**Our Case Number:** ABP-319023-24

**Re: Strategic Infrastructure Development ABP – 319023-24; Further information ref. 237501.0530RR01a received 20/08/2024 for proposed Combined Cycle Gas Turbine (570MW) and an Open Cycle Gas Turbine (140MW) Thermal Power Plant and electricity grid connection including 2 no substations and associated buildings, plant, site works services and ancillary development on land within the townlands of Knockdrin, Derrygreenagh, Derryarkin, Derryiron, Ballybeg, Coolcor, Barrysbrook, Clonin, Togher and Coole, Co. Offaly.**

Appendix 16.3 of the EIAR [document Ref. 237501.0530RR01a dated 03/07/2024] - was reviewed by the Authority. The Health and Safety Authority can confirm, from the details received, that the development will constitute a new lower tier COMAH establishment.

## **Appendix 1**

DRAWING No.: **S7060-8050-0040-1** Sheet 1 of 8 REVISION: **R1.0**

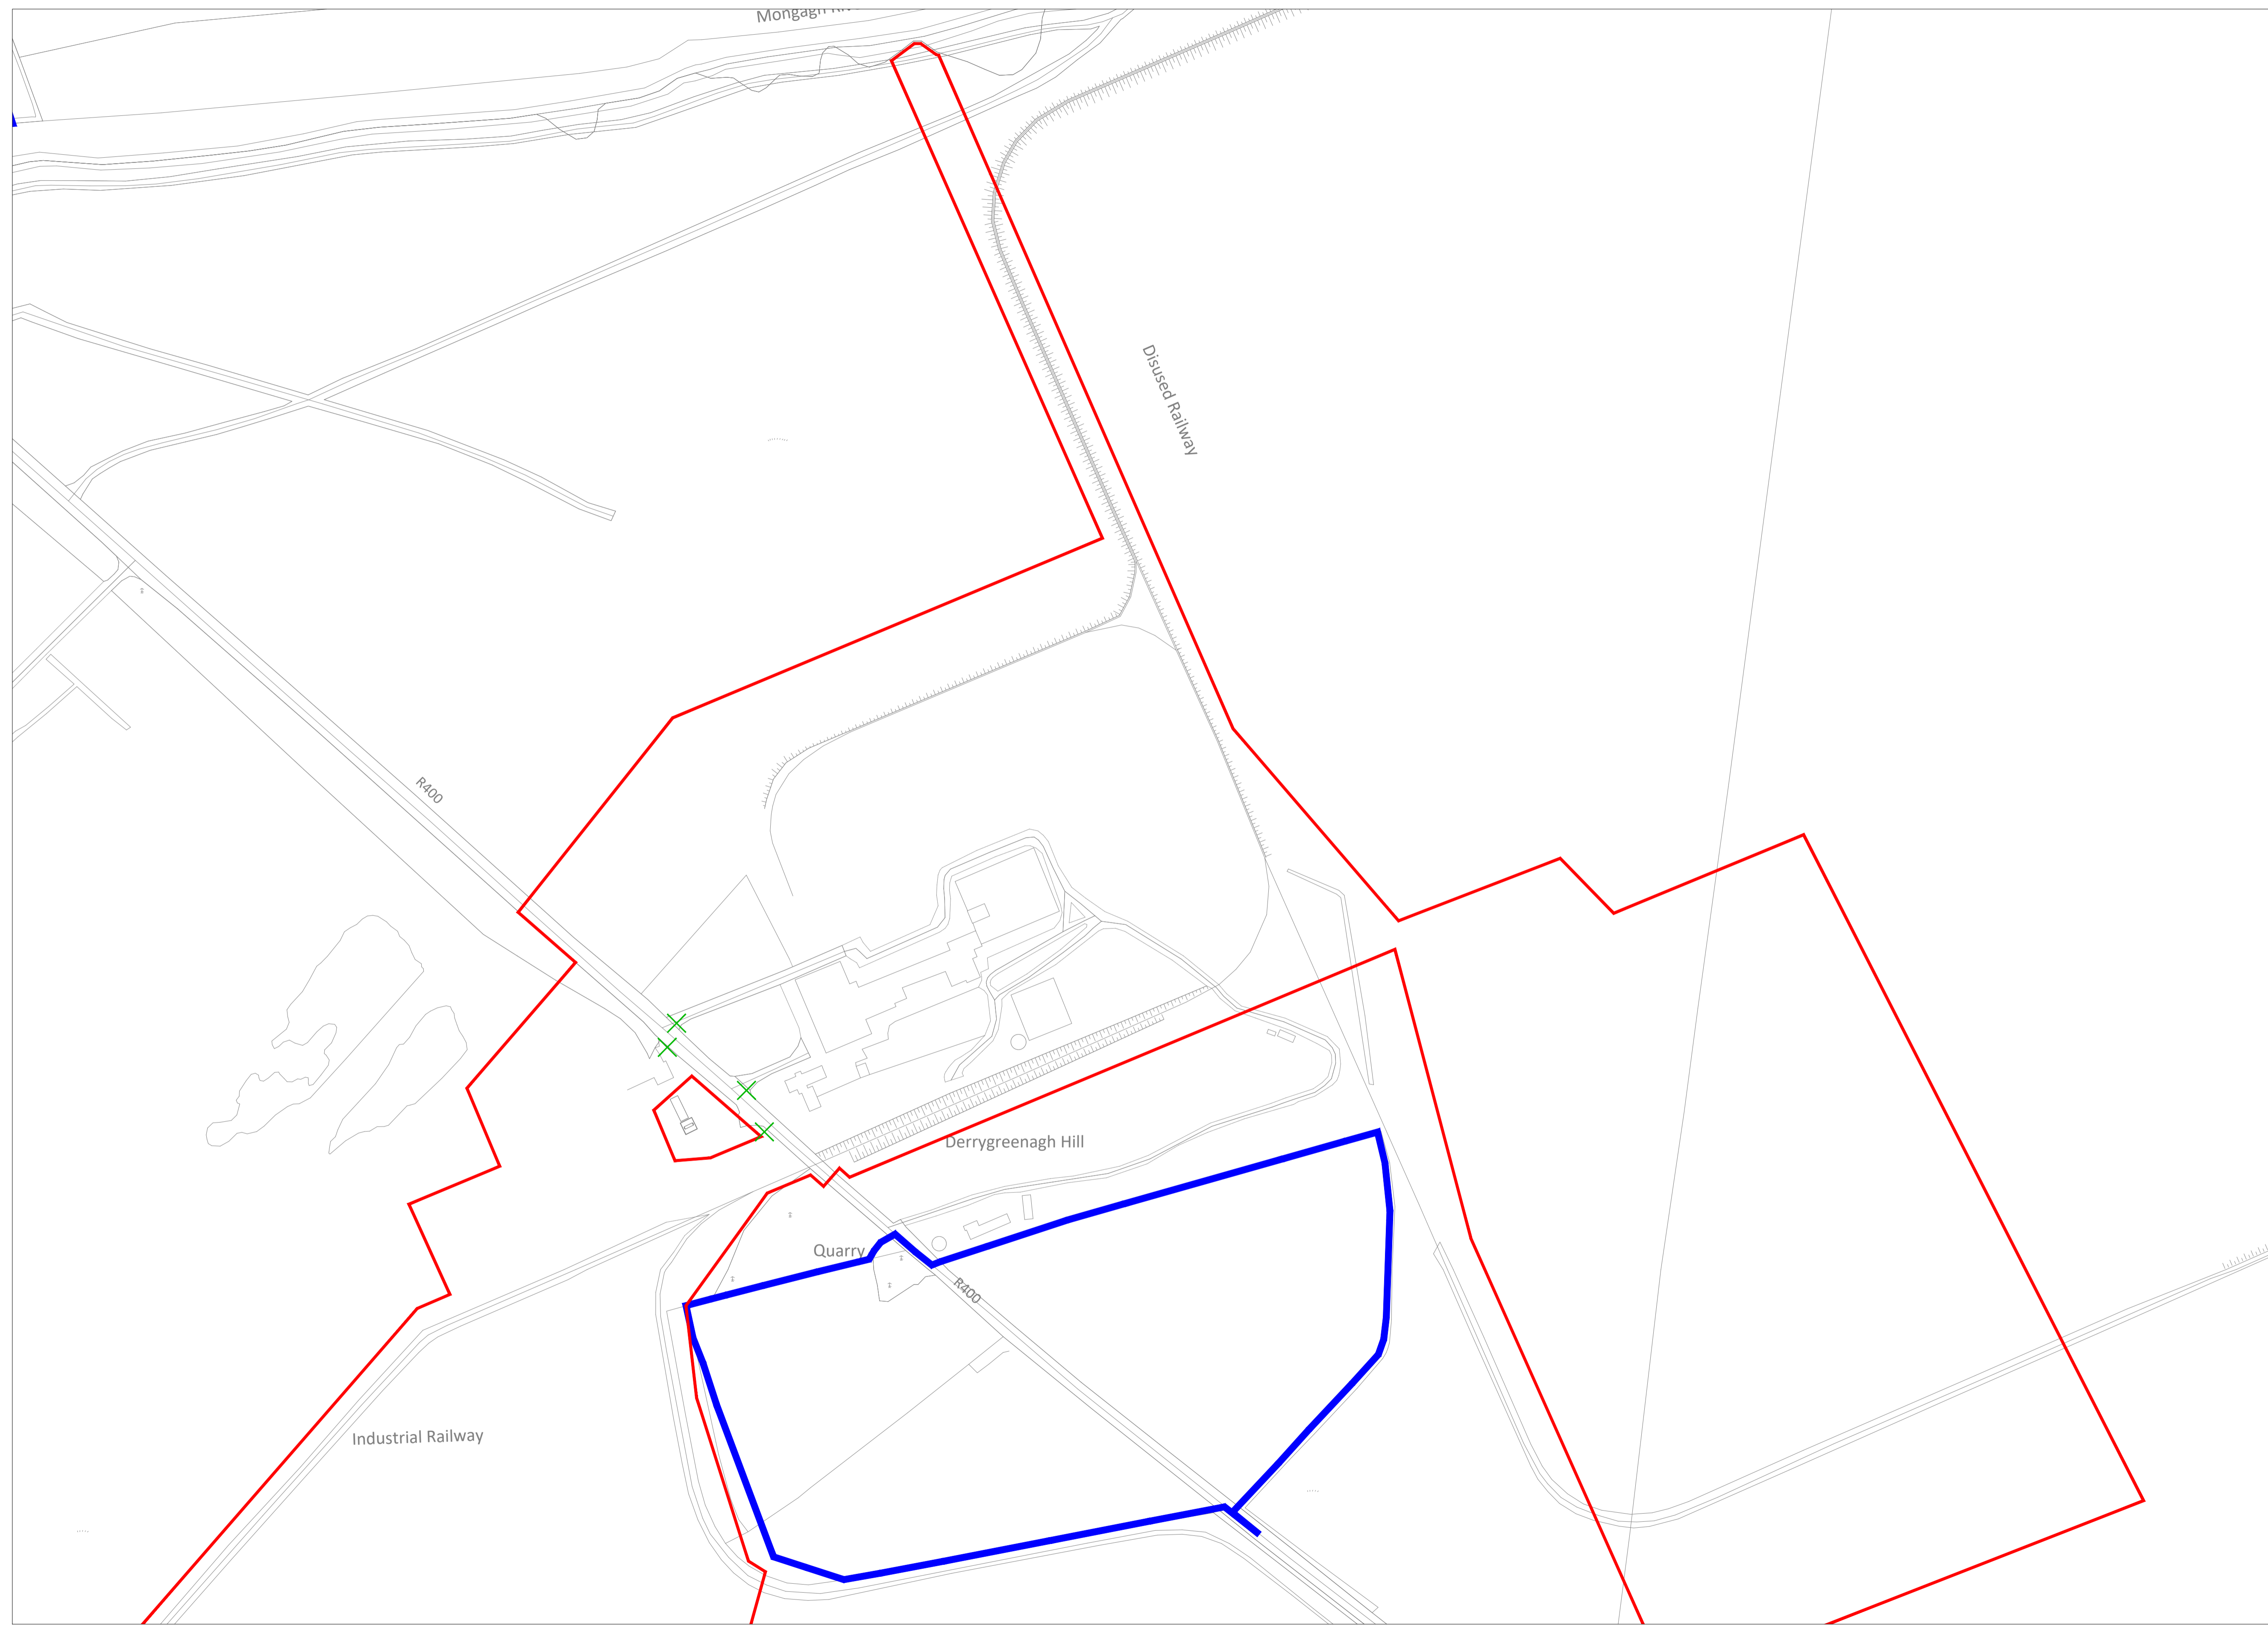
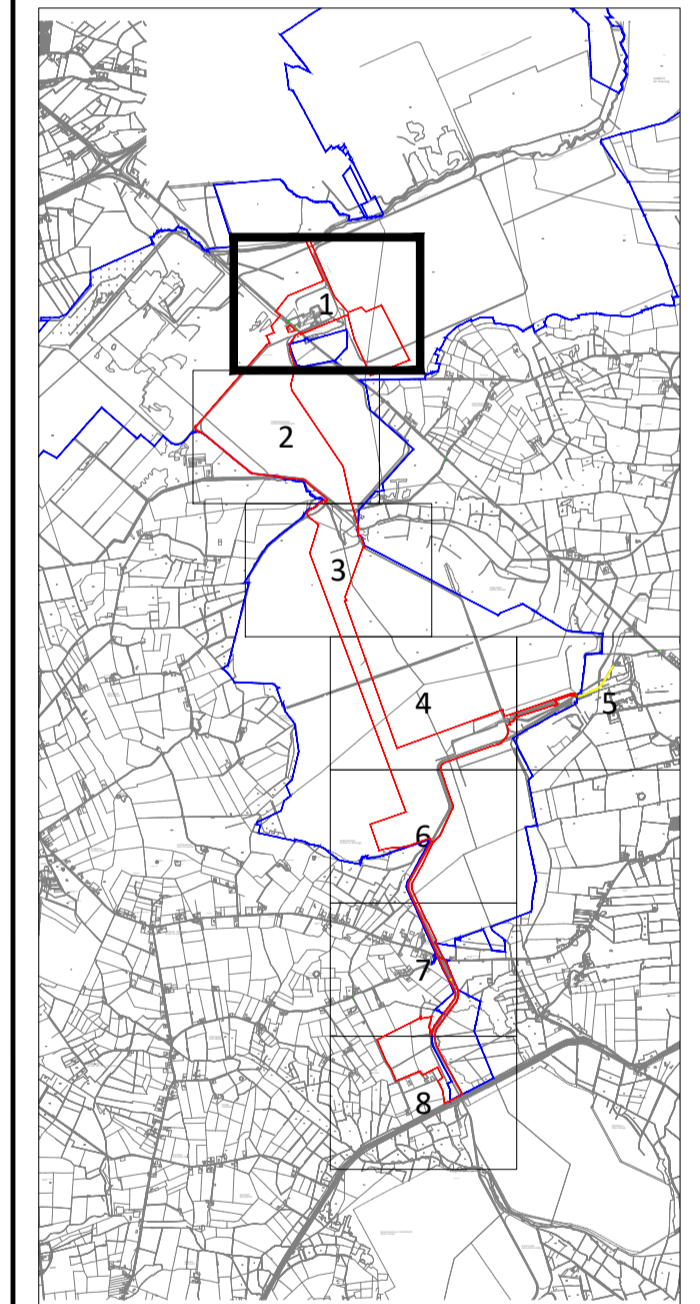
3. Fig 1 site boundary [red line indicating proposed planning application site boundary] is different to fig. 2 COMAH boundary. Also, the site boundary indicated in Appendix 16.3 of EIA is different to that on the proposed development site location map sheet 1 of 8. Ref. S7060-8050-0040-1Rev 1.0. All operations and activities associated with the COMAH site must be incorporated within the COMAH site boundary. Further clarification on this boundary is required.
